Review Response

Project Name: Seda Dock Repair

Response To: SHL23-015 and SEP23-004 SUB2 Review Letter; 5912 E Mercer Way, Mercer Island, WA 98040

SHEET
13.0
NWS-2022-XXX
PAGE 13 OF 17

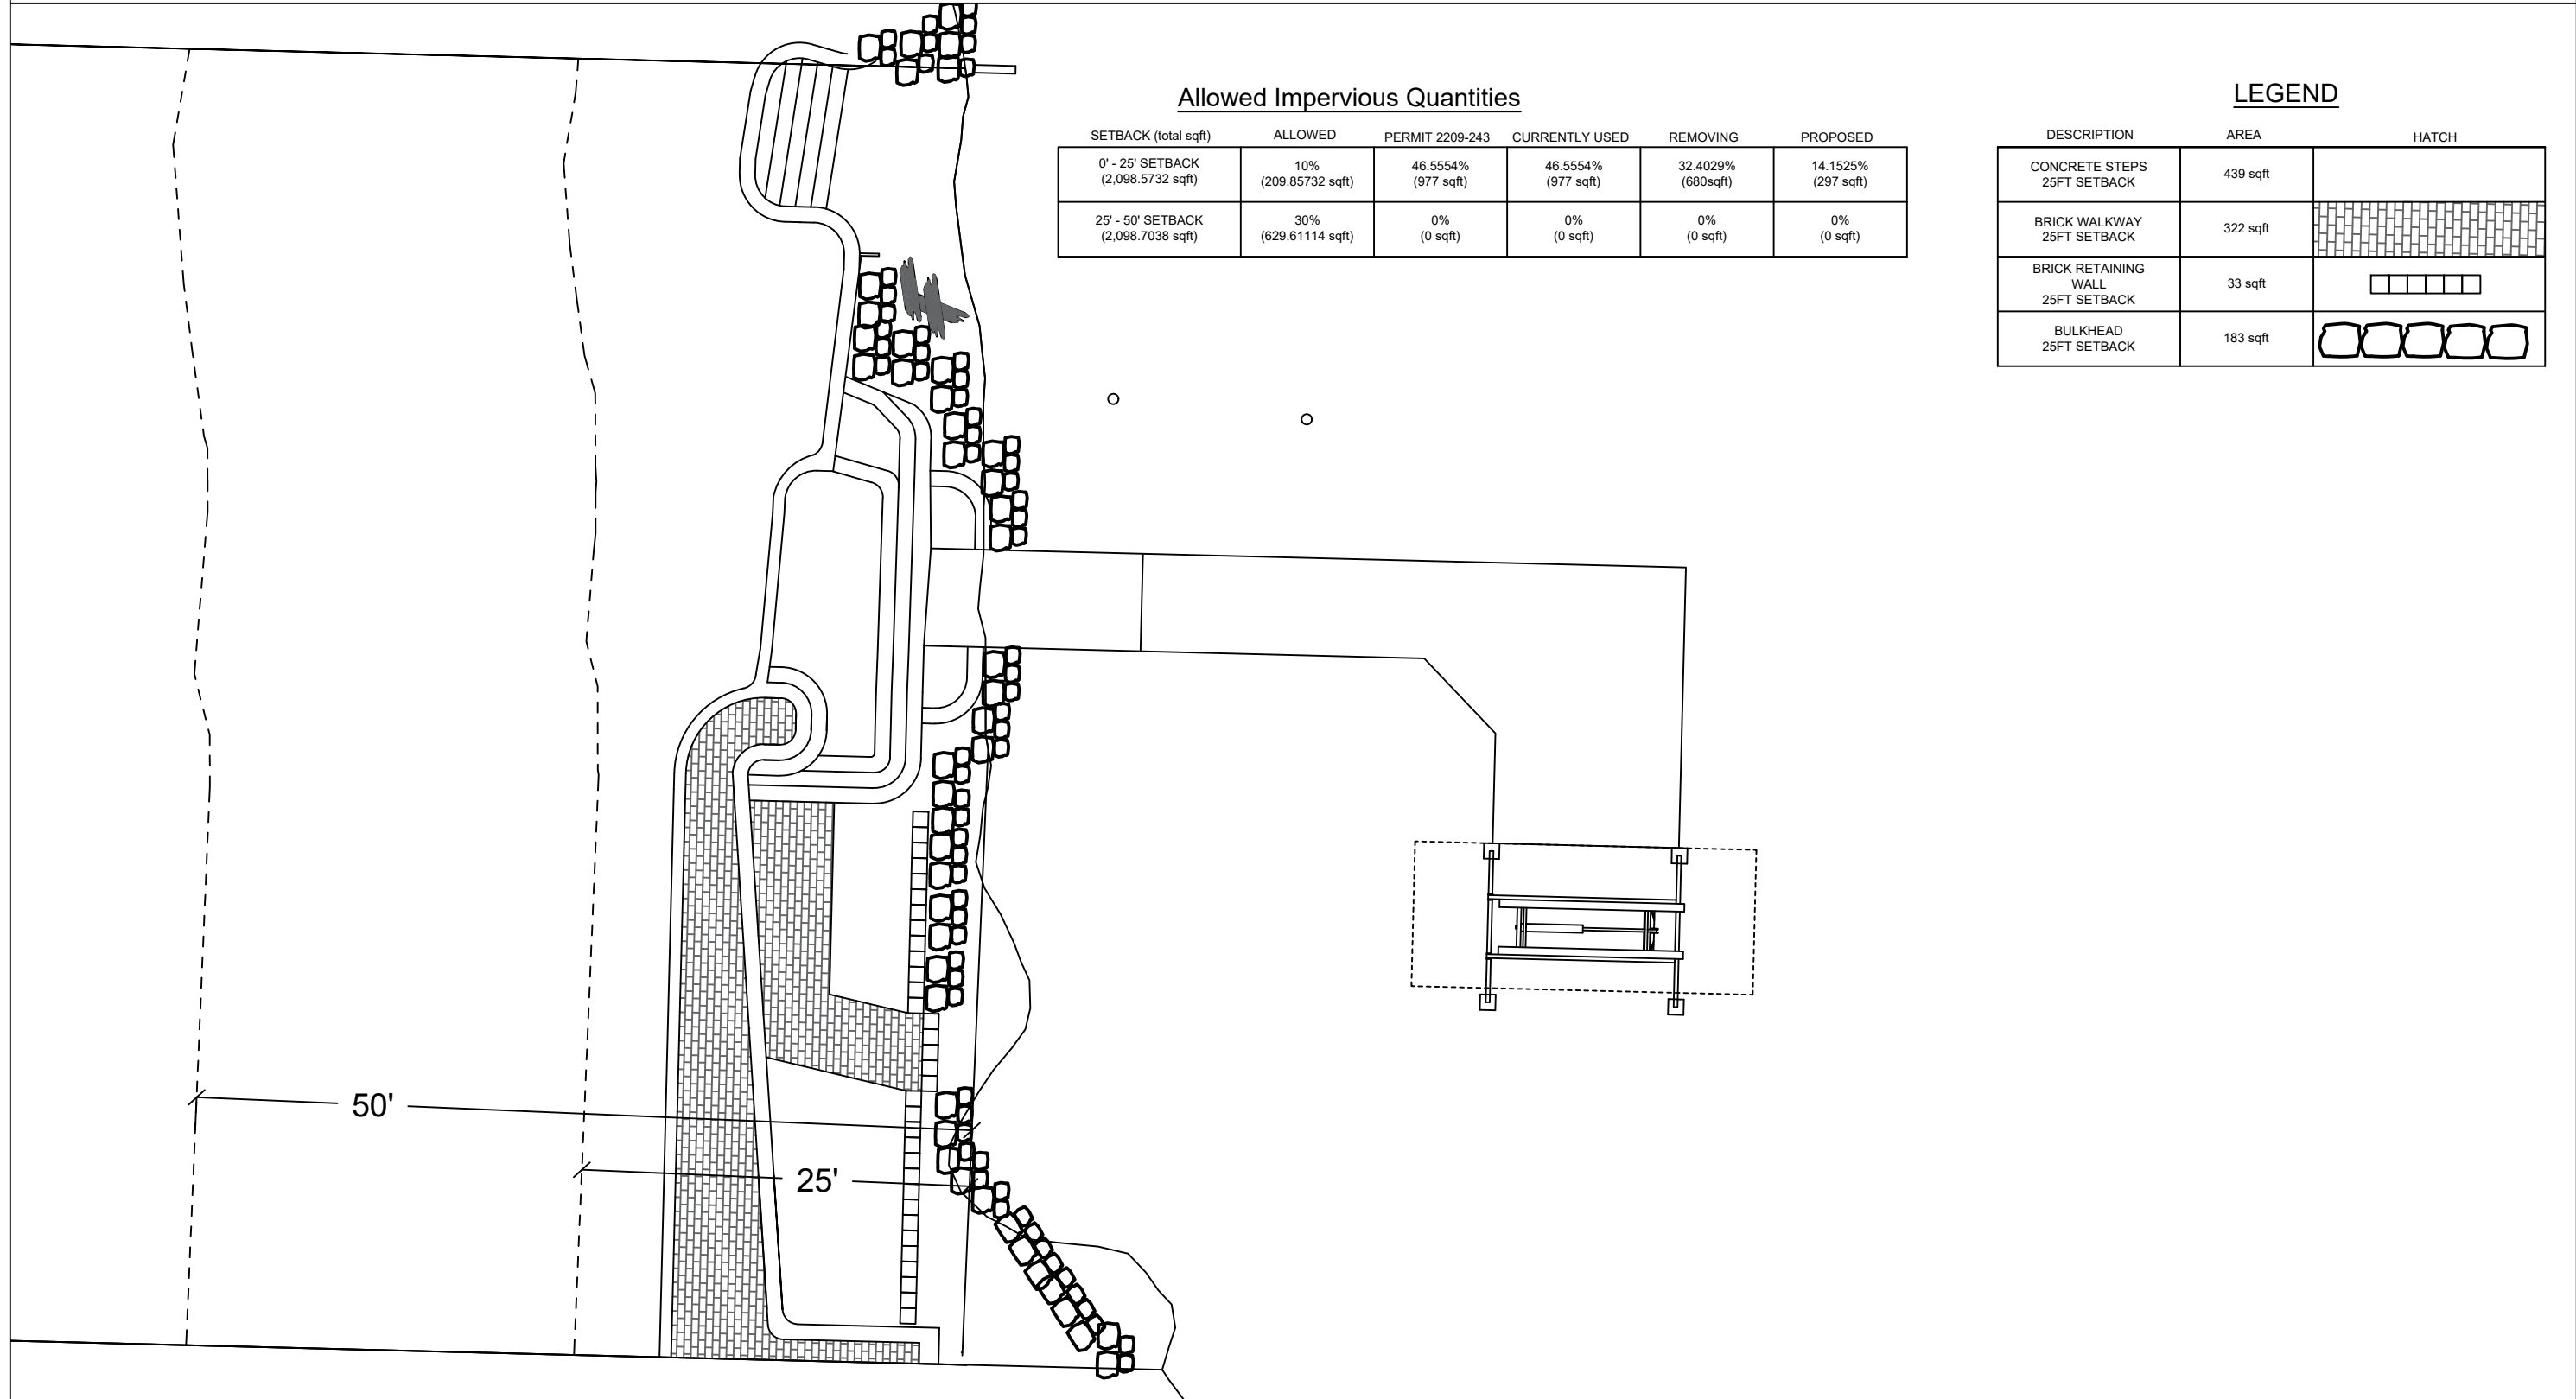
1. Please revisit the surface coverage calculations and diagrams shown on sheet 14.0 of the plans:

a. Aerial imagery shows that there may be a shed located within 50 feet of the OHWM. Add this shed and any other hardscape onto the diagram and include in calculations if within 50 feet of the OHWM.

Please see the updated plan noting the updated square footage and hardscape calculations.
